KIRKLEES METROPOLITAN COUNCIL INVESTMENT & REGENERATION SERVICE

DELEGATED DECISION TO DETERMINE APPLICATIONS FOR CONSENT, AGREEMENT OR APPROVAL REQUIRED BY CONDITION

Reference No:	2025/44/91826/W
Site Address:	former Lloyds Bank, 22, Carr Lane, Slaithwaite, Huddersfield, HD7 5AN
Description:	Discharge of details reserved by conditions 3 (drainage scheme), 5 (noise), 6 (sound attenuation measures), 7 (noise management plan) and 8 (kitchen extract system) on previous permission 2023/93076 for external alterations to former bank building to form restaurant, installation of extract ventilation system (class Eb) (within a Conservation Area)
Recommending Officer:	Joshua Merriman

DECISION – DISCHARGE OF SPLIT DECISION

DRAWING TITLE		AS FITTED
INTERNAL EXTRACT DUCT MAIN CANOPY		
DRAWING NUMBER	REV	
19148-002	B

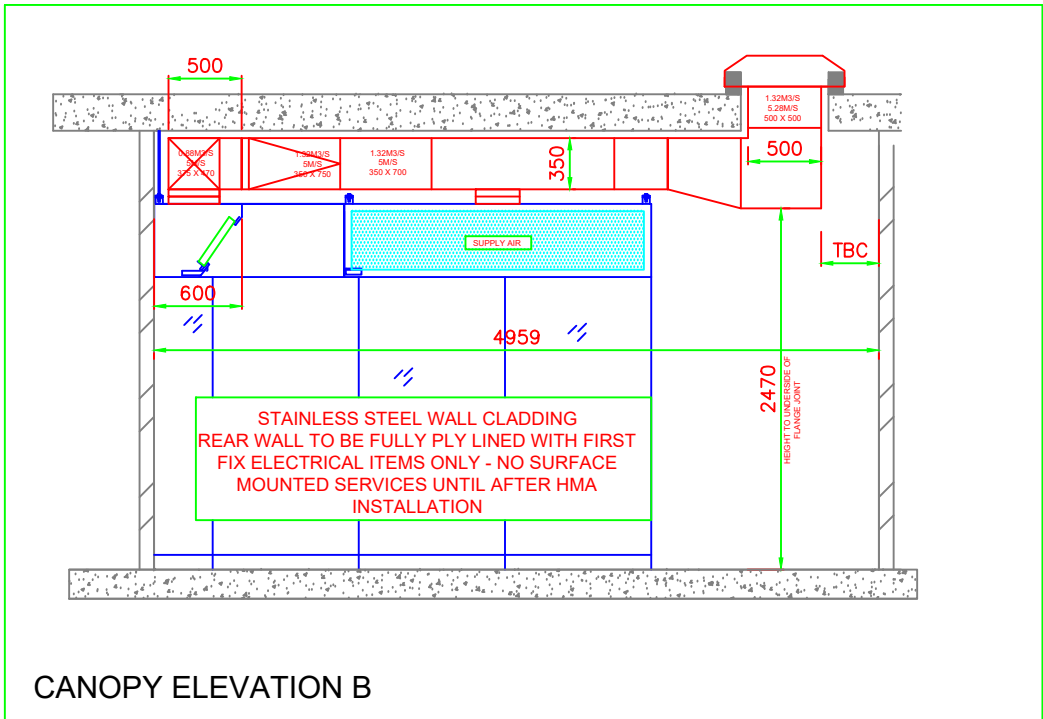
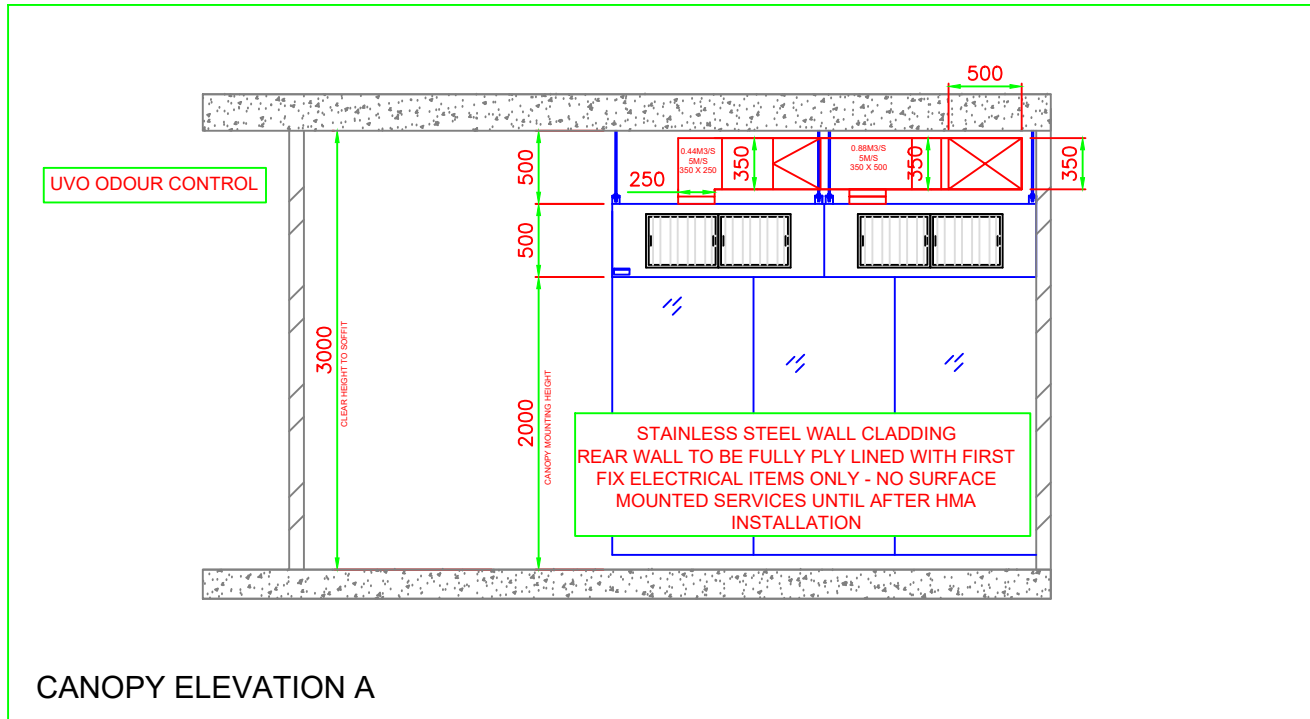
“The applicant has submitted an EMAQ Report authored by Purified Air dated 14 August 2024 Ref EH29812Rev4. The risk assessment scores the odour at 38 indicating a high level of odour control is necessary. It proceeds to highlight a proposal for an ESP followed by UV ozone system to achieve the same level of control as point 1 (Fine filtration or ESP followed by Carbon filtration). The submitted drawings from HMA Ventilation show the installation of 2no. ESP systems and 1no. UVO system.

The response of the Environmental Health Team goes on to set out the maintenance regime is not submitted as part of the submitted scheme.

The submitted information is accepted insofar as it relates to the requirements of the condition other than the requirement for an ongoing maintenance schedule that will be carried out to ensure that the extract system continues to effectively control odours and not cause excessive noise.

In this case the submitted scheme fails to show the maintenance regime required to ensure there is no loss of amenity through a failure to maintain the installed mitigation measures.

The scheme submitted fails to show the maintenance regime required to ensure there is no loss of amenity through a failure to maintain the installed mitigation measures. the maintenance regime will need to be in line with the EMAQ Guidance as set out in the [response](#) of the Environmental Health Team.
